TRANSPORT FOR LONDON

LOWER THAMES CROSSING – WRITTEN SUBMISSION OF ORAL COMMENTS MADE AT ISSUE SPECIFIC HEARING 10

DEADLINE 6: 31 OCTOBER 2023

E. Work No. 9Z (Sheet 66) – Walking, Cycling, Horse Rider bridge over A127

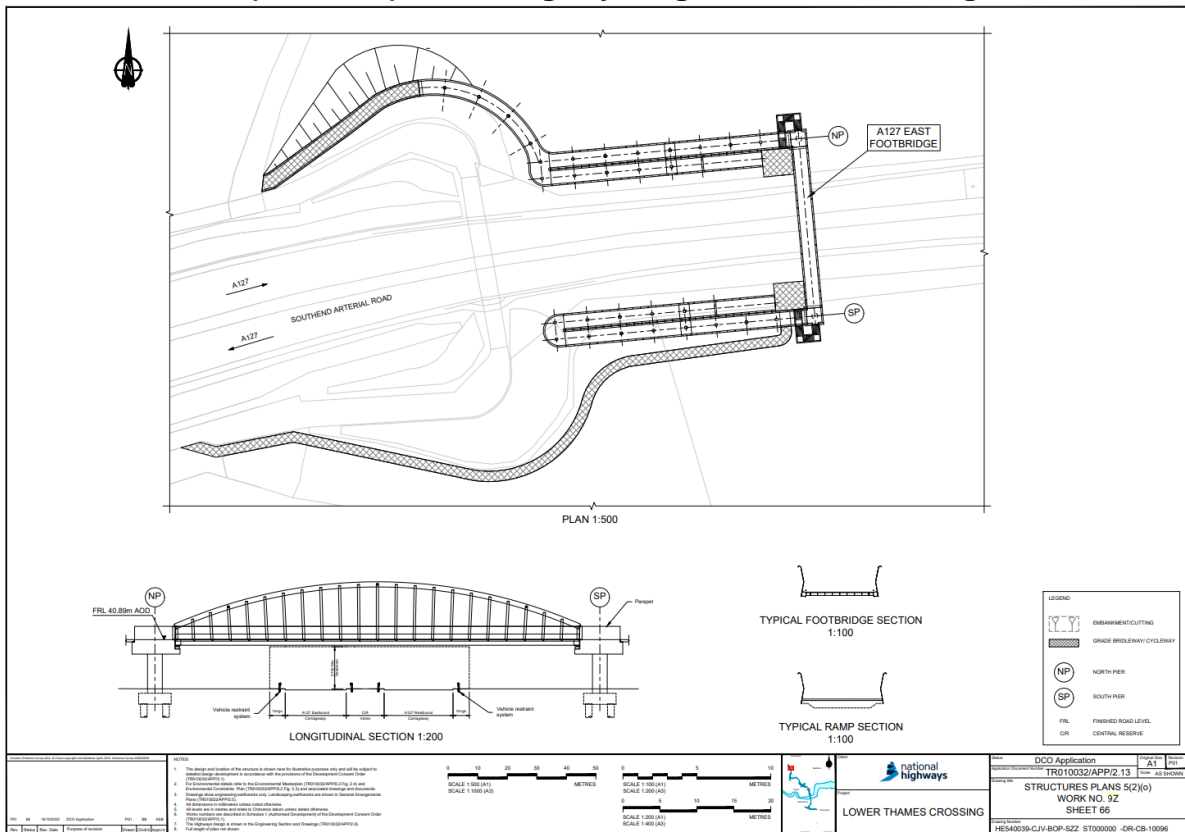
- 3.6 TfL also noted at the hearing that questions have been raised about whether an at-grade crossing would be more suitable instead of a grade-separated bridge. TfL would have significant concerns about introducing a new at-grade crossing at this location. The substantial increase in forecast traffic flows on the A127 caused by the Project, with around 700-800 additional Passenger Car Units (PCUs) per hour forecast at peak times in each direction as soon as the Project becomes operational, would cause significant safety concerns for an at-grade crossing.

- 3.7 Furthermore, Design Manual for Roads and Bridges (DMRB) standards clearly show that an at-grade crossing would be unsuitable for a two-lane dual carriageway with a 70 miles per hour (mph) speed limit. With regards to pedestrians and cyclists, the following standards are relevant:

- CD 143 Designing for walking, cycling and horse-riding Paragraph E/4.4 states: *“Stand-alone signal controlled crossings for pedestrians and cyclists shall not be provided where the 85th percentile speed exceeds 50mph.”*

- CD 195 England National Application Annex – Designing for cycle traffic Paragraph E/4.1 states: *“Suitable types of cycle crossing – speed limit greater than or equal to 60 mph – no alternative to grade separated. Signal controlled cycle crossing could be acceptable based on traffic flow and number of lanes if speed limit is reduced to 50mph but preferred crossing type would still be grade separated.”*

- LTN 1/95 Section 4.2.3 states with regard to zebra crossings: *“Where traffic speeds are higher than 30 m.p.h., people will require longer gaps in the traffic flow or be exposed to the risk of more serious injury if precedence is not conceded for any reason. Zebra crossings should not be installed on roads with an 85 percentile speed of 35 m.p.h. or above.”* Section 4.2.4 of the same document states with regard to signal-controlled crossings: *“Caution should be exercised where pedestrian flows are generally light or light for long periods of the day. Drivers who become accustomed to not being stopped at the crossing may begin to ignore its existence, with dangerous consequences. The problems are accentuated as vehicle speeds increase.”*

- With specific regard to equestrian crossings, CD 143 Designing for walking, cycling and horse-riding states in Paragraph 5.23: *“At-grade equestrian crossings shall not be provided on: (1) roads with a 120 kph design speed...”* Further information is provided in Paragraph 5.25: *“Where an at-grade equestrian crossing is provided on a dual carriageway, a holding area of 5.0 metres wide by 3.0 metres long shall be provided in the central reserve.”* There is insufficient space in the central reservation of the A127 to provide a holding area of this size. Finally, Paragraph 5.25.1 states: *“At-grade equestrian crossings should only be provided on dual carriageways where alternative crossings are not possible.”* The design of the proposed WCH bridge shows that an alternative crossing at this location is feasible.

3.8 In conclusion, TfL’s position is that while demand for the new WCH bridge is not known, a grade separated crossing of the A127 west of M25 Junction 29 remains necessary as mitigation for the impacts of the Project – as originally set out by the Applicant – to provide a route that is safe and addresses the severance caused. While it also helps address existing severance, this does not detract from the fact that it is primarily required to tackle the additional severance directly caused by the Project.
